**From:** Laura Gibbons <Laura.Gibbons@arun.gov.uk>  
**Sent:** 22 September 2020 15:56  
**To:** Planning.Responses <Planning.Responses@arun.gov.uk>  
**Cc:** Simon Davis <Simon.Davis@arun.gov.uk>  
**Subject:** Y/72/20/RES- Land at Stakers Farm, Yapton

Engineers Comments Regarding Surface Water Drainage

PERMEABLE PAVING CONSTRUCTION DETAILS

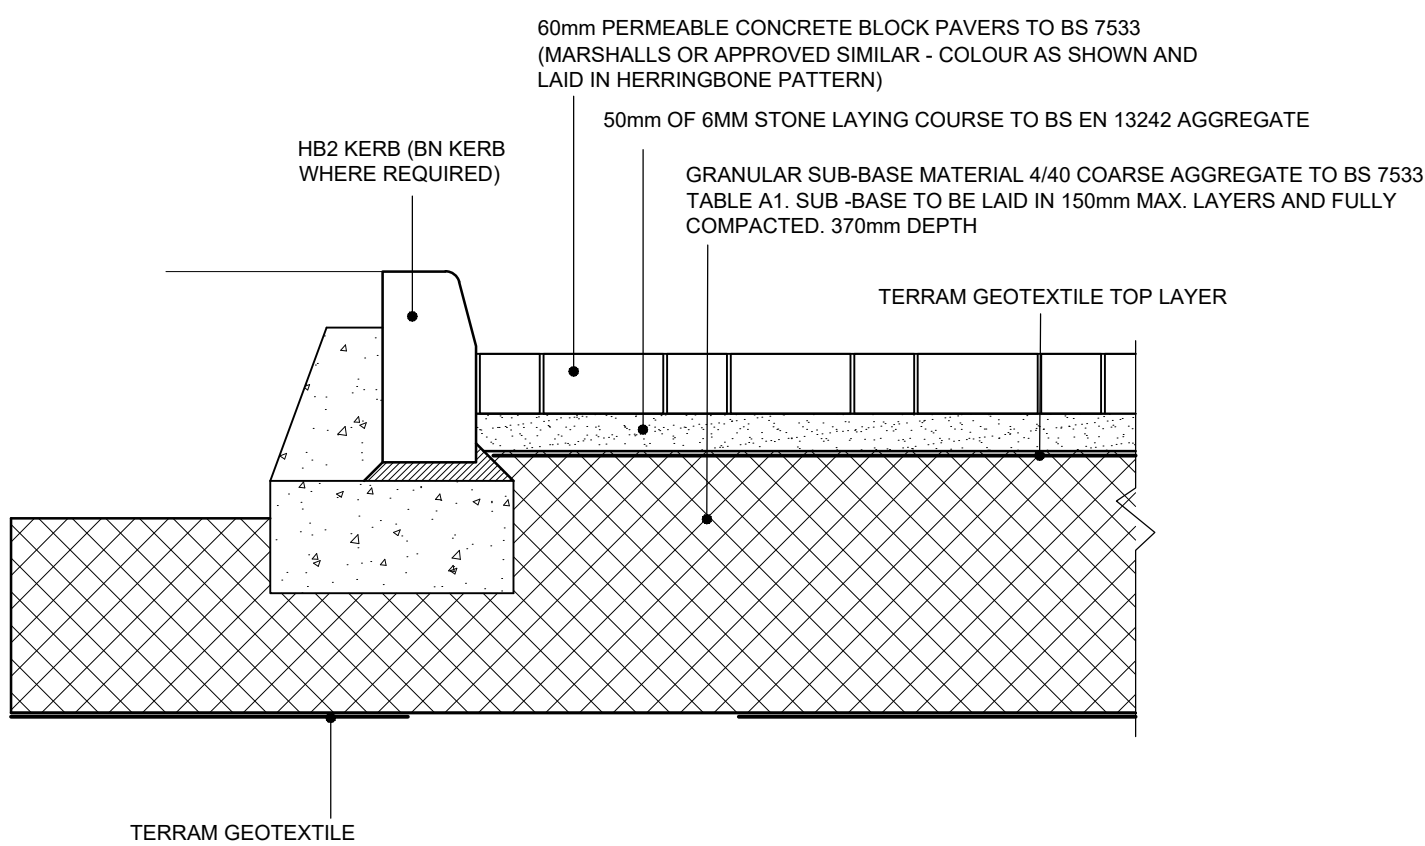
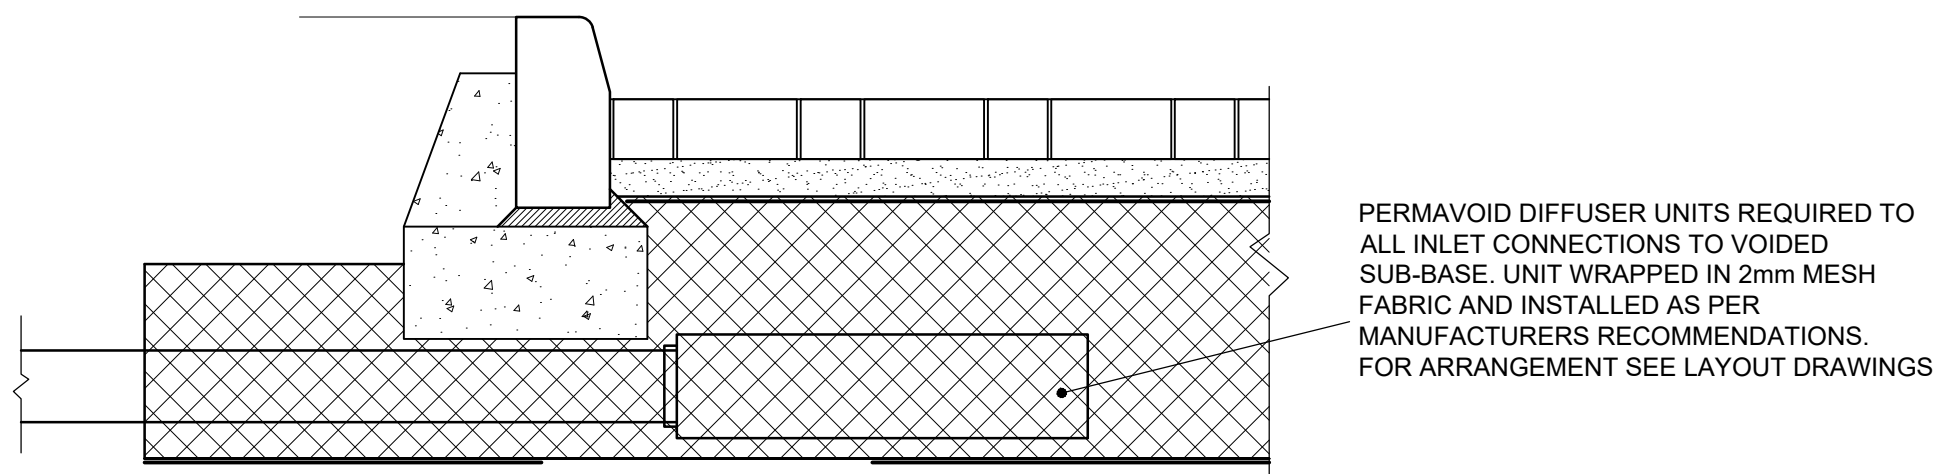
1. The checklist has been corrupted as part of the scanning process. However, it is understood from previous dialogue and the adjacent site that all infiltration devices are kept to a maximum of 600mm depth. Yet many areas of permeable paving have a sub-base proposed beyond 600mm depth. Please review or provide evidence that all features are located above peak recorded groundwater level, i.e. put groundwater levels on the drainage plan.

2. It is understood that the permeable paving areas will not have a flat sub-base, please provide spot levels on the drainage layout showing finish and formation levels of permeable paving.

INFILTRATION BASIN WITH INFILTRATION BLANKET BENEATH

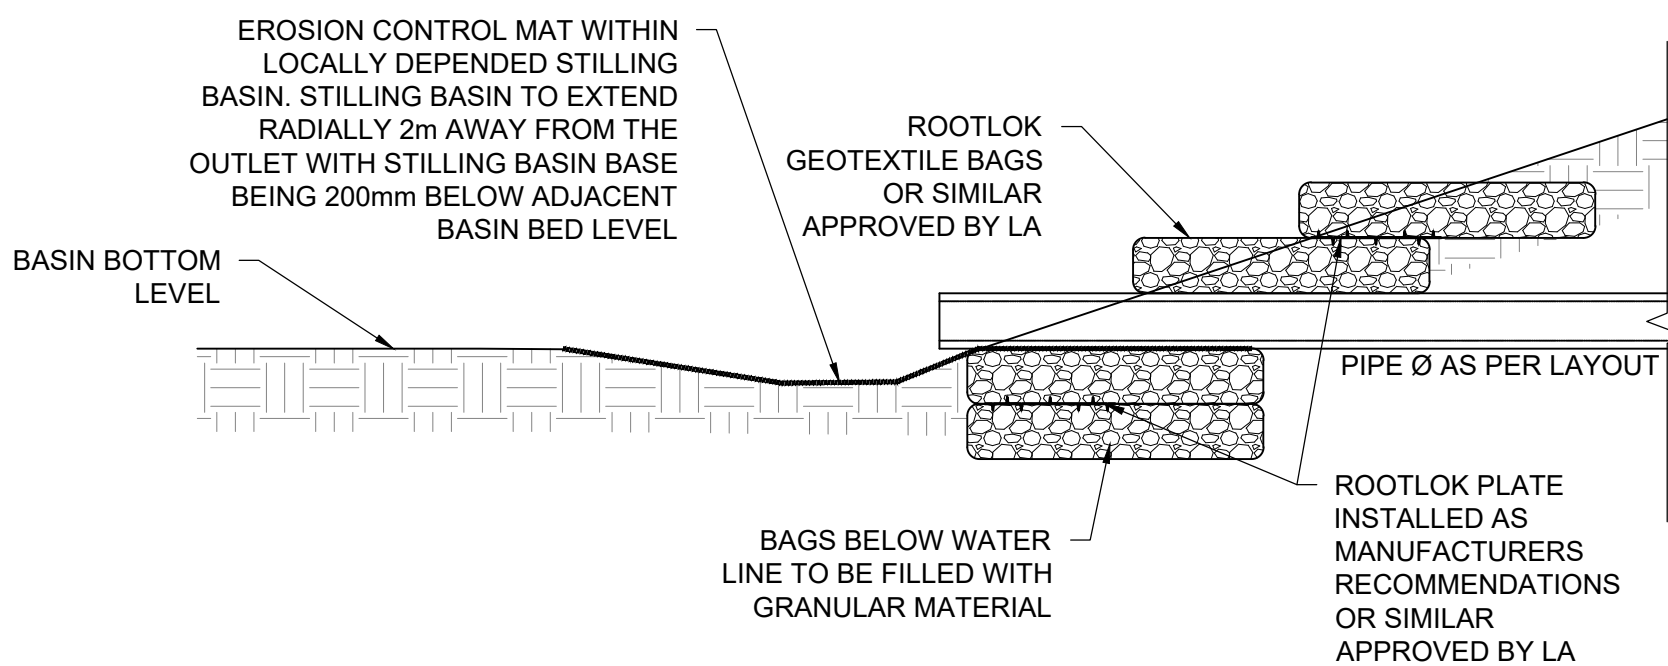
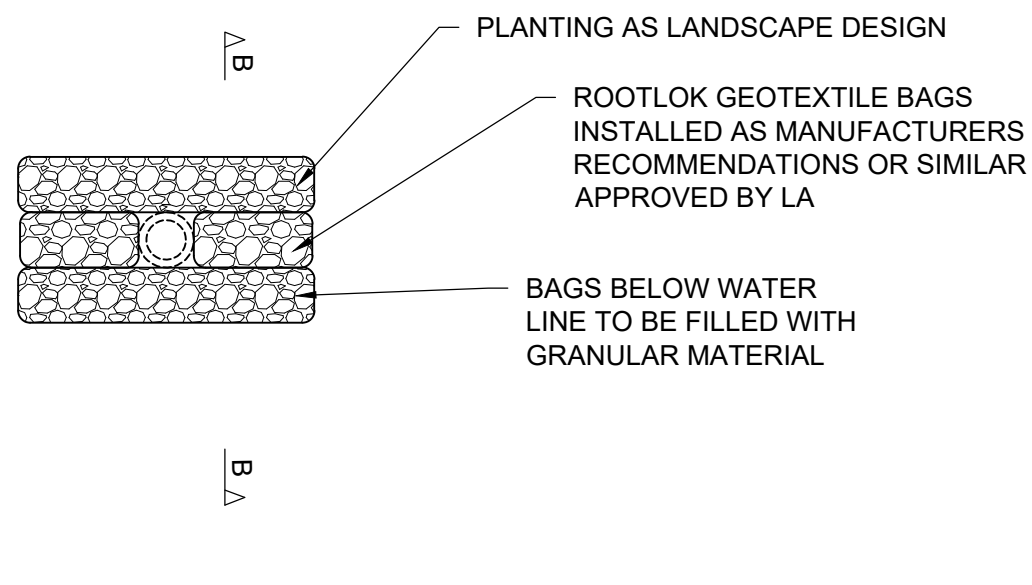
1. Successful resolution of the above reserved matters points.
2. Please provide two perpendicular site specific cross sections of the proposed infiltration basin. These should show invert level, maximum water level, bank level, construction including connection between sub-base and basin.
3. Please provide construction detail drawings of pipe bed and surround.
4. Please clearly indicate on plans where the different permeable paving types shown on the construction drawing are proposed.
5. The maintenance manual will be reviewed once the design has been agreed.
6. Further comments are likely once details are further reviewed.
